# CITY OF ALBUQUERQUE

RE: **McDonalds – Coors and Hanover**  
**1501 Coors Blvd NW**  
**Grading Plan**  
**(Non-stamped) Plan Date: 1/16/17 (File: J11D037)**

Based upon the information provided in your submittal received 1/30/2017, the Grading Plan is not approved for Building Permit. The following comments need to be addressed for approval of the above referenced project:

C7.0

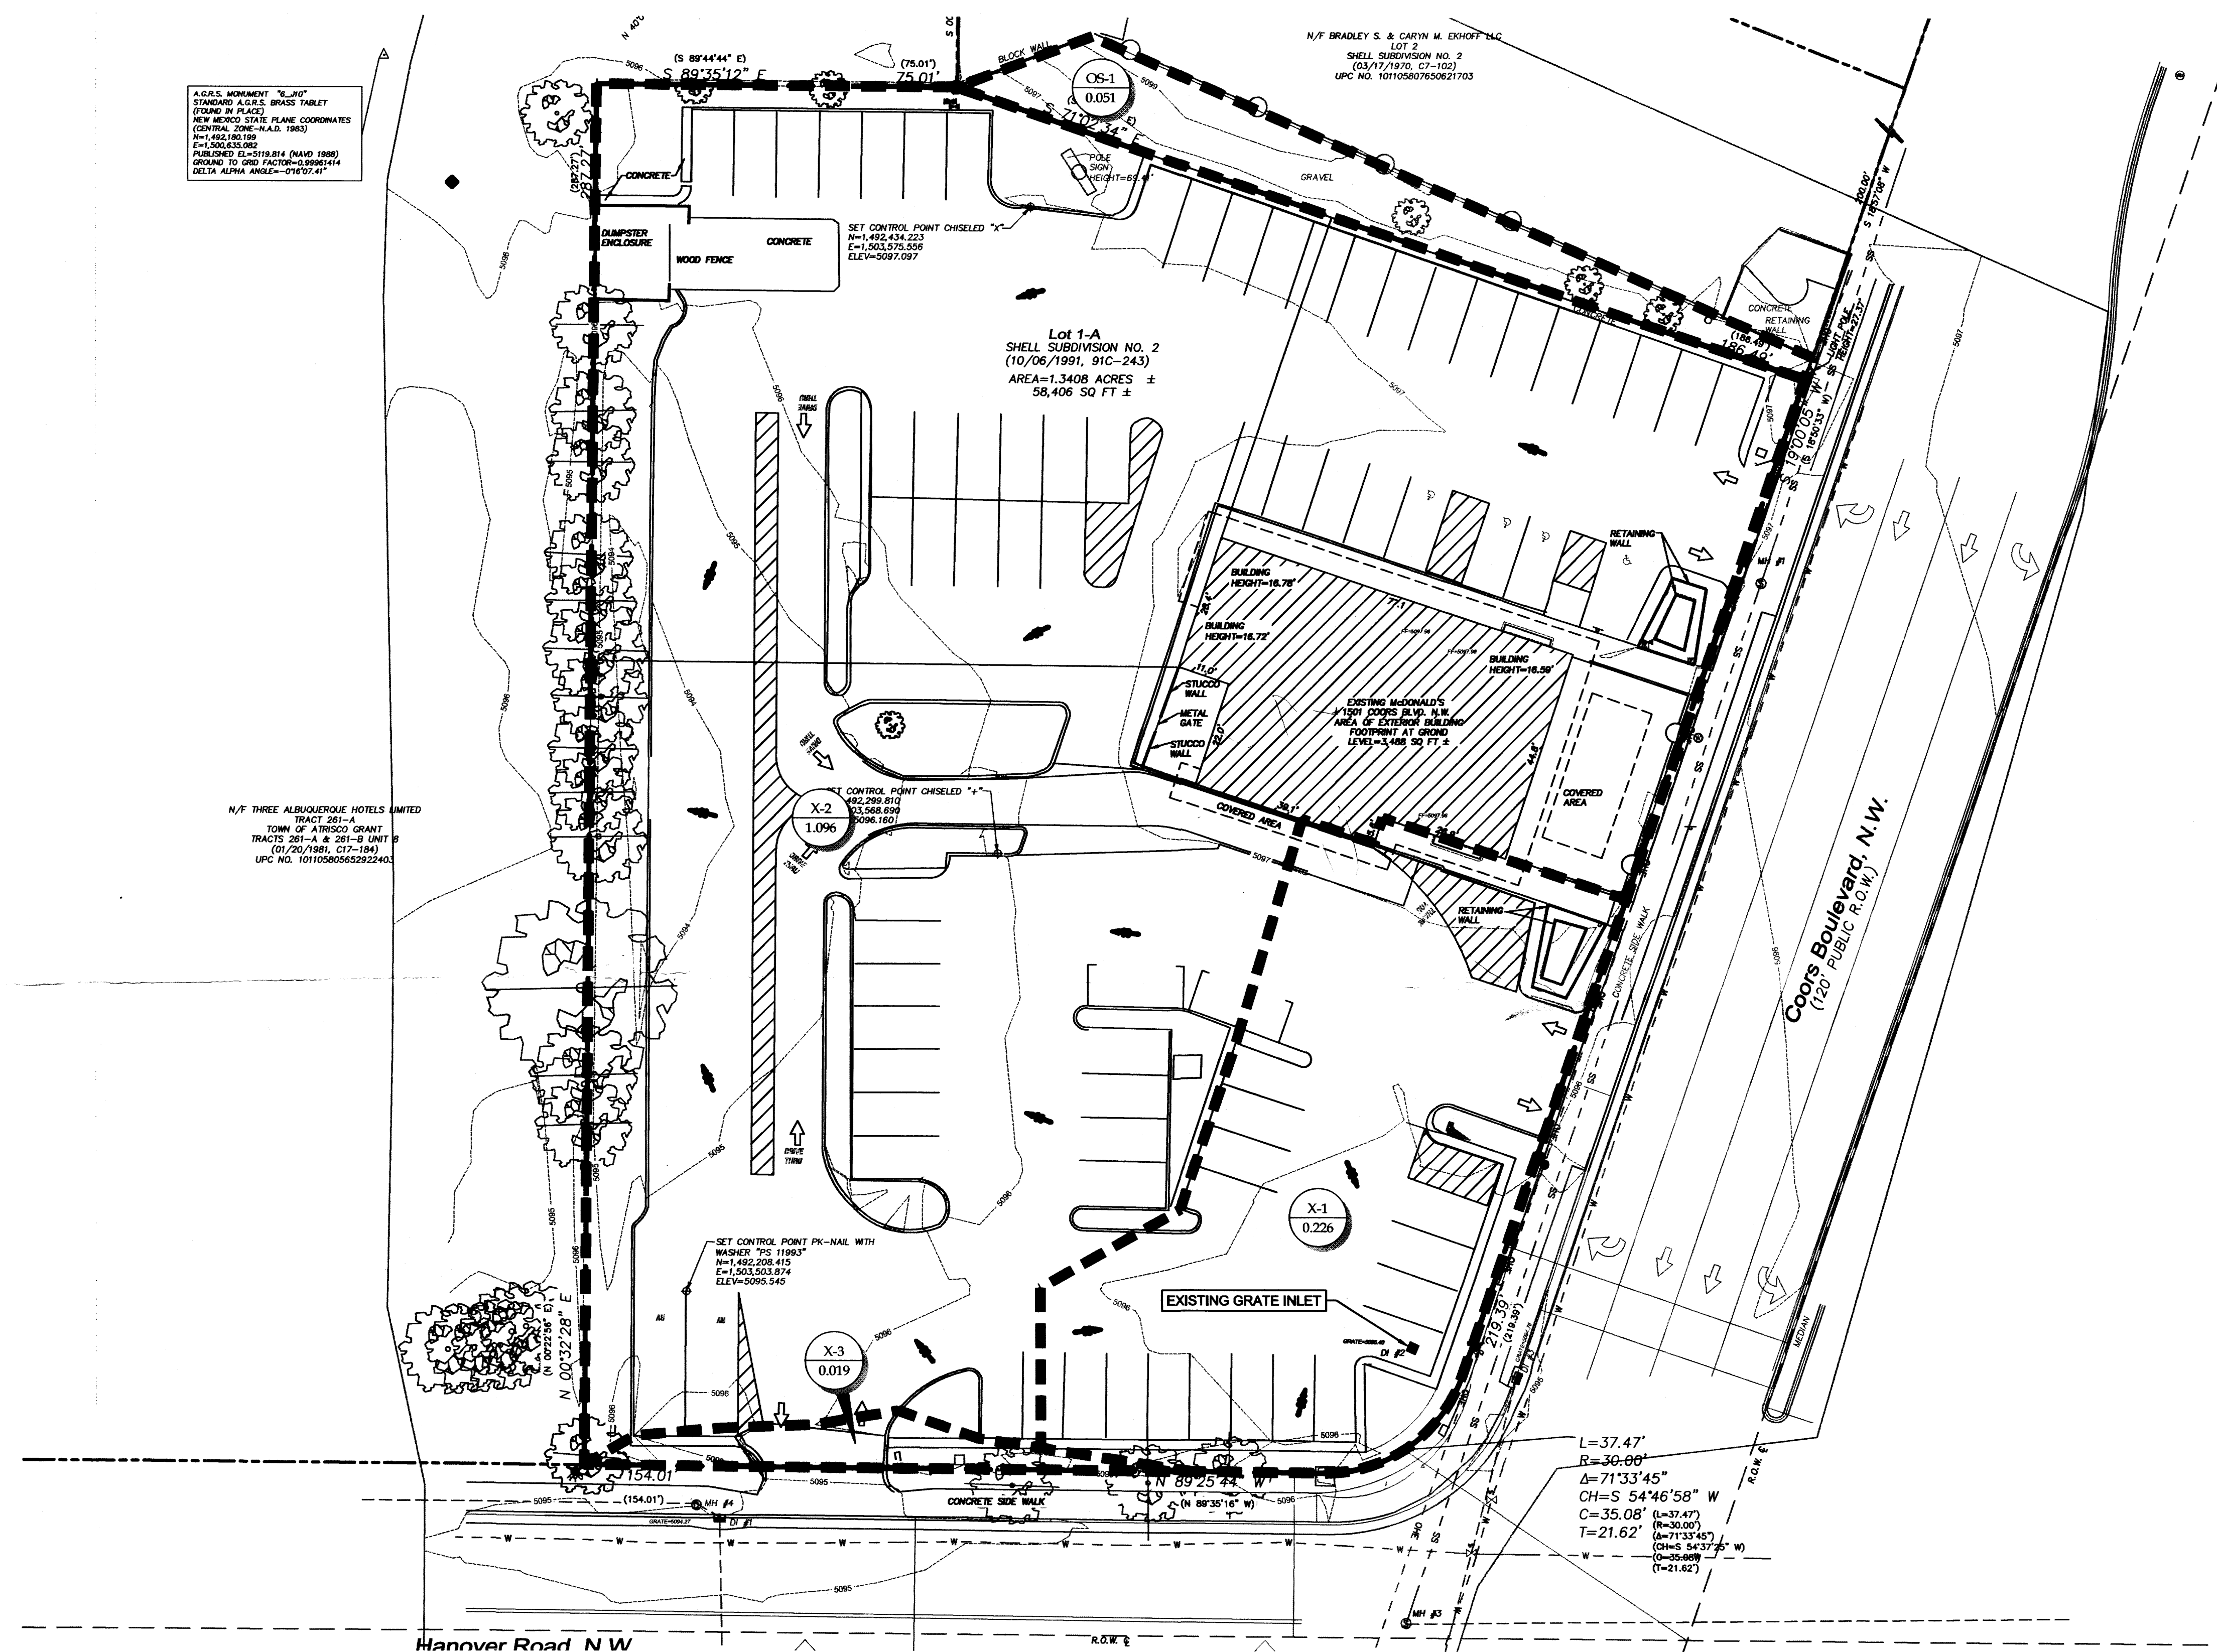
1. Conversion of DI#1 from a Type Single C to a Type Single D requires one of the following as there is no throated inlet less than 150' upstream of this catchment:

- a. A throated drop inlet (Type A or C) may be added within 150' upstream of DI#1.
  - b. DI#1 may be replaced with a Type Double-D inlet. This seems to be the more feasible option.

2. For connections to City Facilities, storm drain material must be RCP Class 3 or 4, PVC, Ductile Iron Pipe, or HPPP (High Performance Polypropylene Pipe). This applies to STRM-4 tying into MH#4. Additionally it may be more feasible to tie directly into the back of DI#1.

3. Will adjustments be needed to raise or lower MH#4 on Hanover? This is currently on the sidewalk and is proposed to be in the drivepad.
4. Ensure the fence around Bio-retention Areas 3 and 4 is at least 42" in height.

5. Waterblocks, at least 8" high from top of pavement on the drivepad to bottom of gutter along the road, need to be incorporated at the Coors entrance.
